Development Facilitation Team (DFT) – Review Comments

Project No: PR-2020-004098 Date: 05/21/2025 Agenda Item: #4 Zone Atlas Page: K-09

Legal Description: Tract A-1, BRIDGEPOINT SUBDIVISION

Application For: MAJOR_PLT- 2025-00006 – PRELIMINARY PLAT

PLAT GEOMETRY

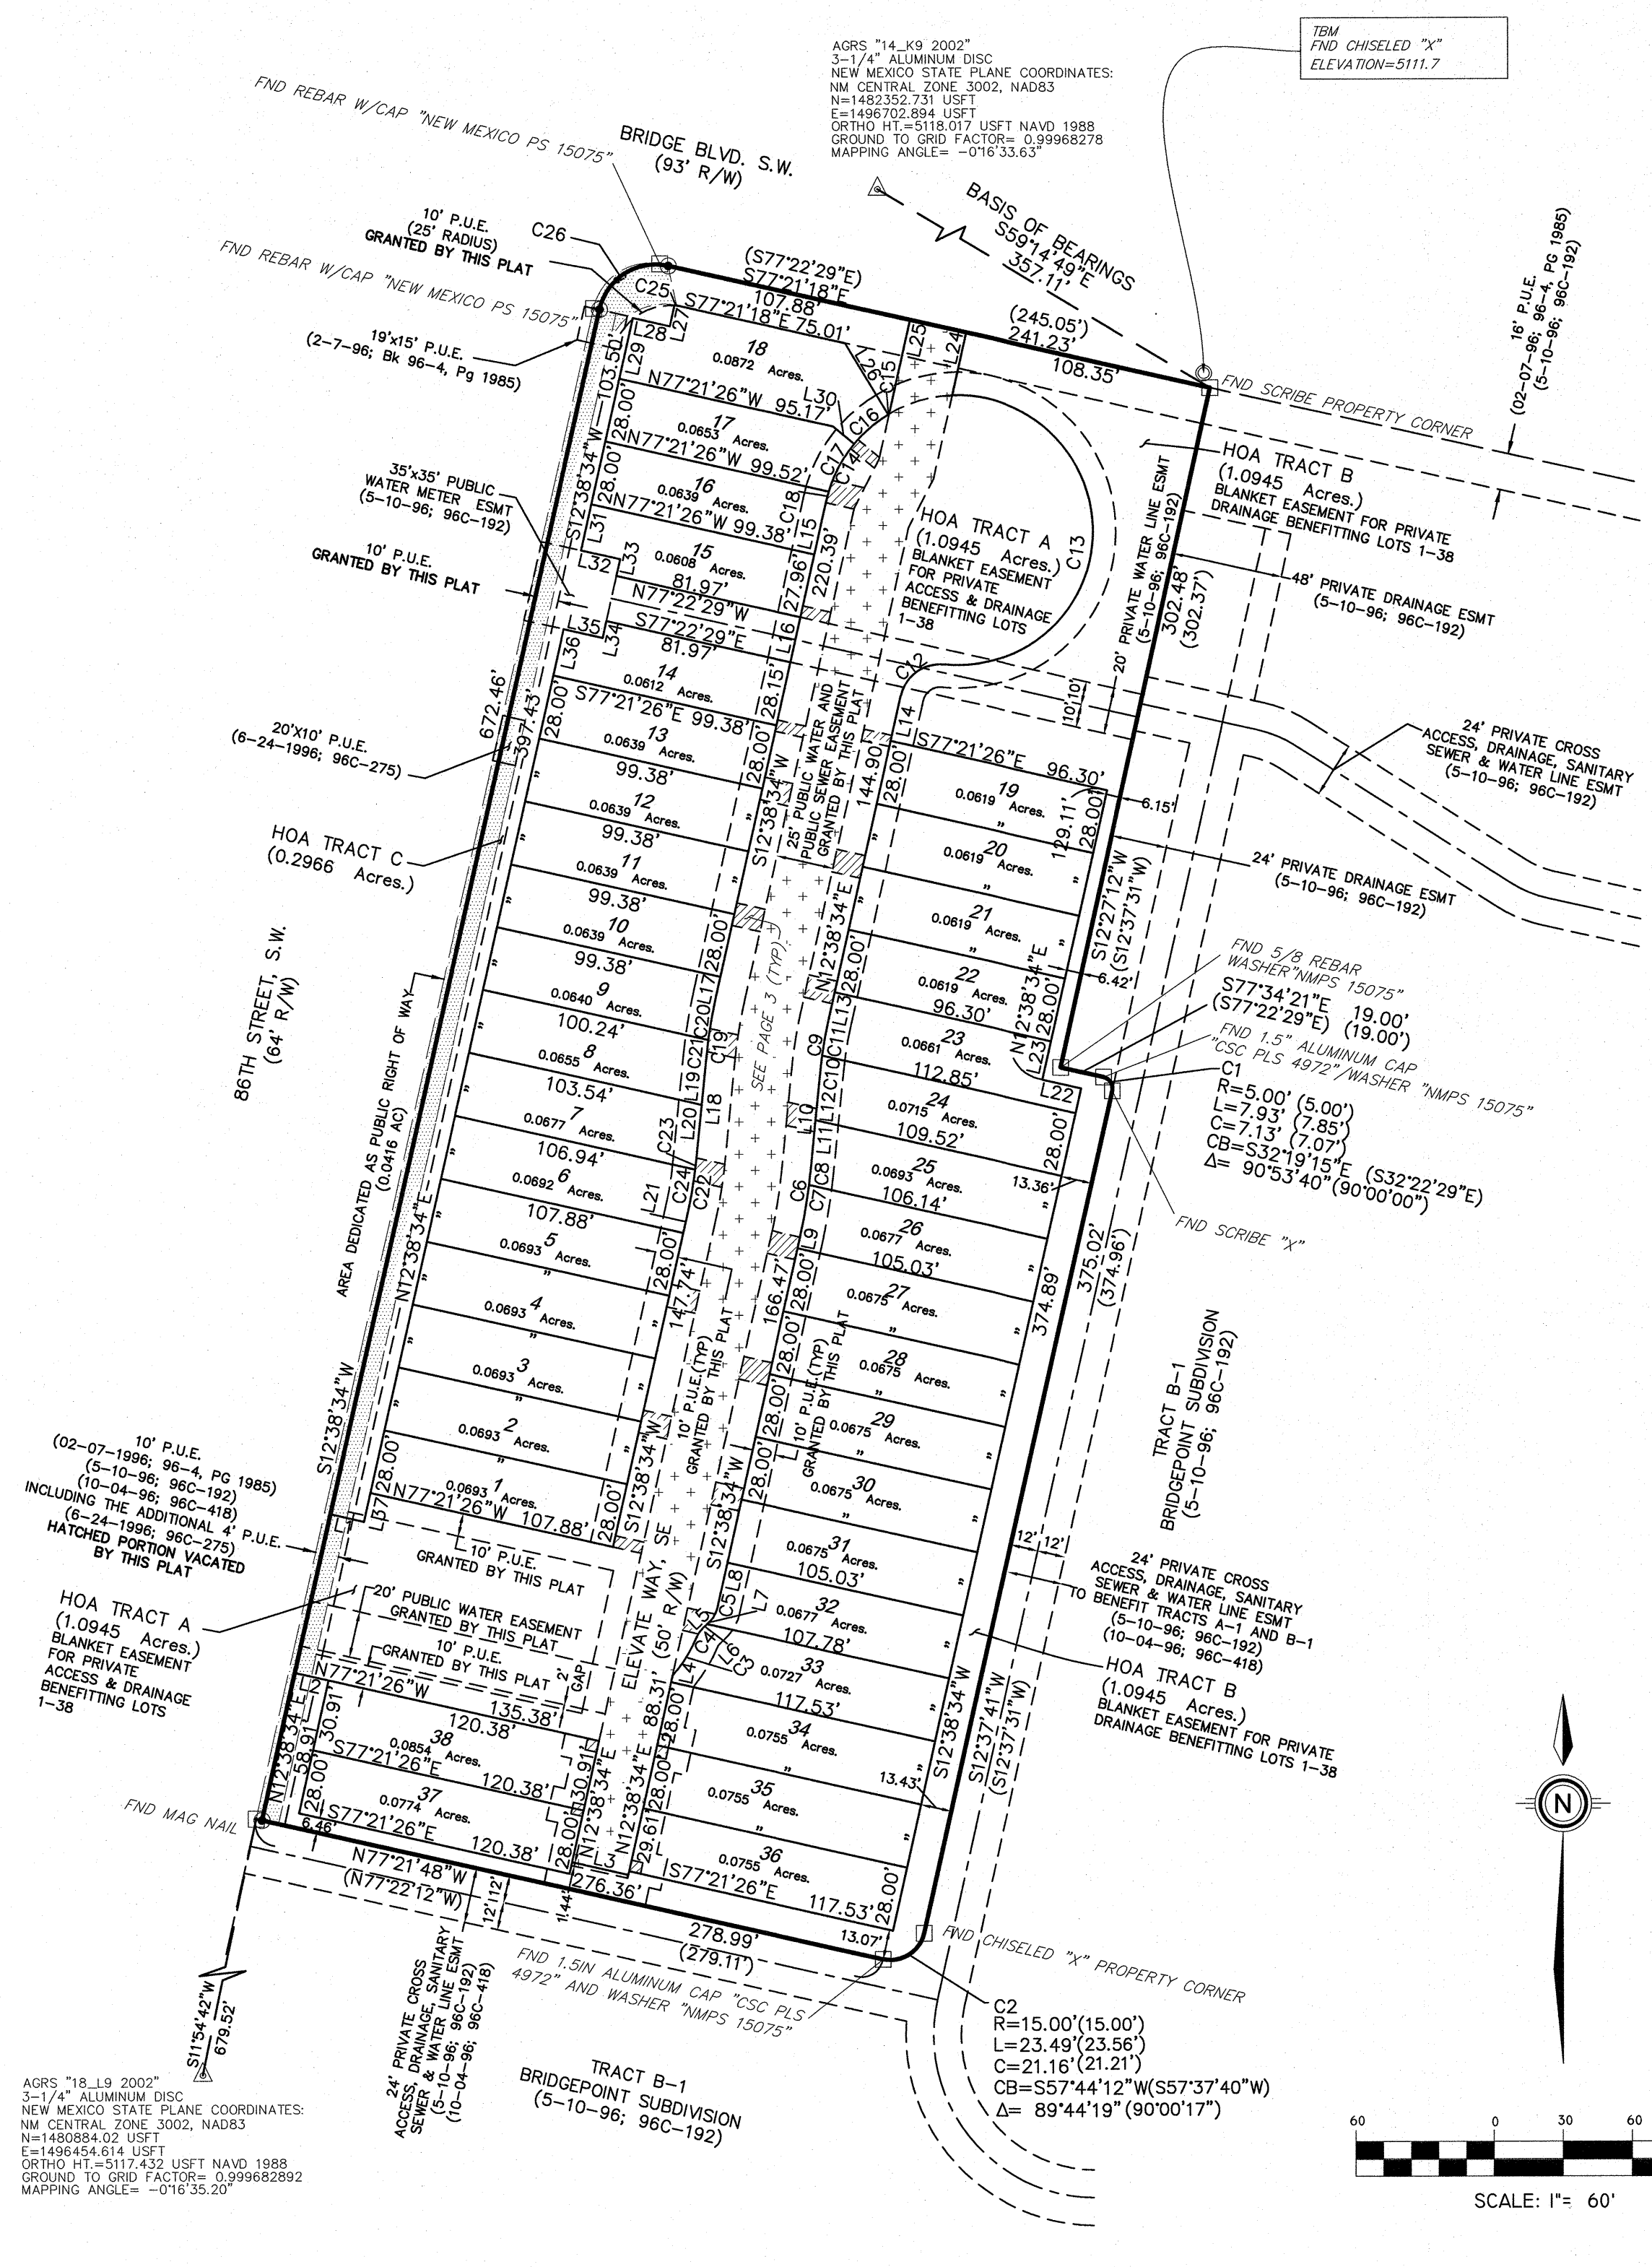
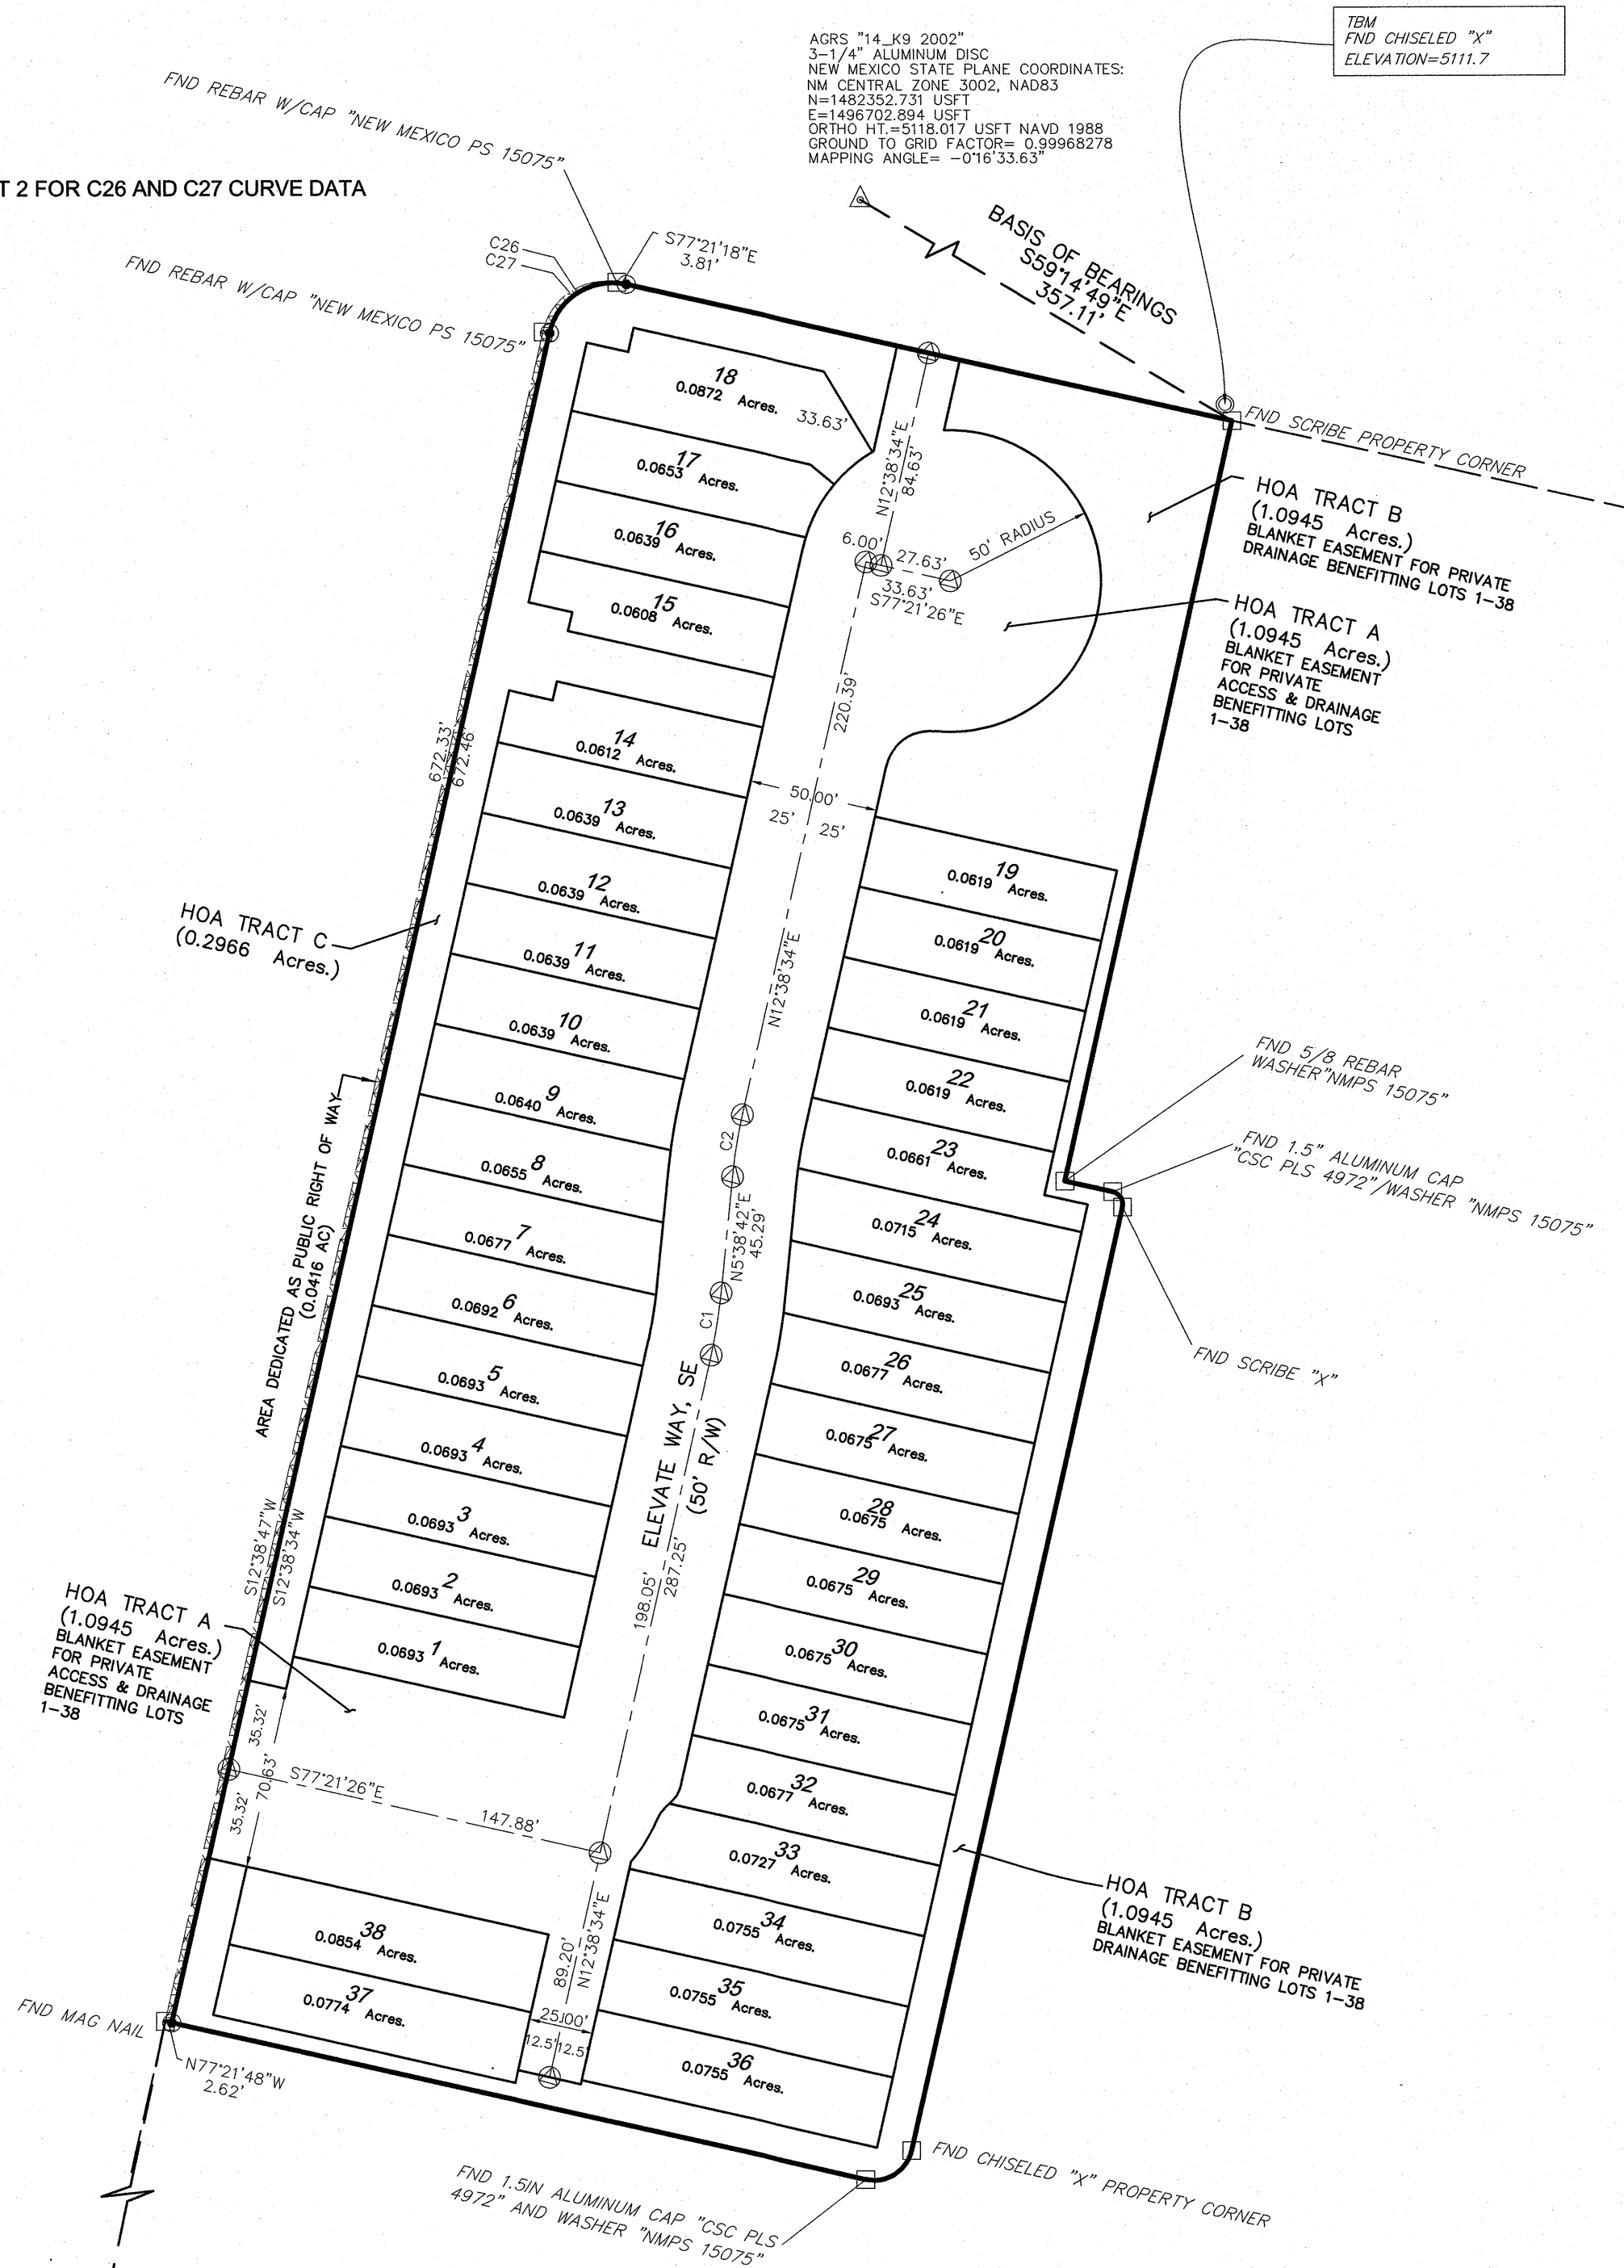
1. Availability Statement 240808 provides conditions for service.
 - a. Infrastructure improvements are required and must be constructed or financially guaranteed prior to final sign off.
2. The proposed 10' PUE along the west property boundary is encroaching into the existing water meter easement. Please revise so that is not the case.
3. A portion of the public meter easement is encroaching into the proposed public right-of-way being granted. Please provide a vacation of the public water meter easement for the portion of the easement within the proposed area being granted for public right-of-way.
4. Please label the adjacent public right-of-way street names.
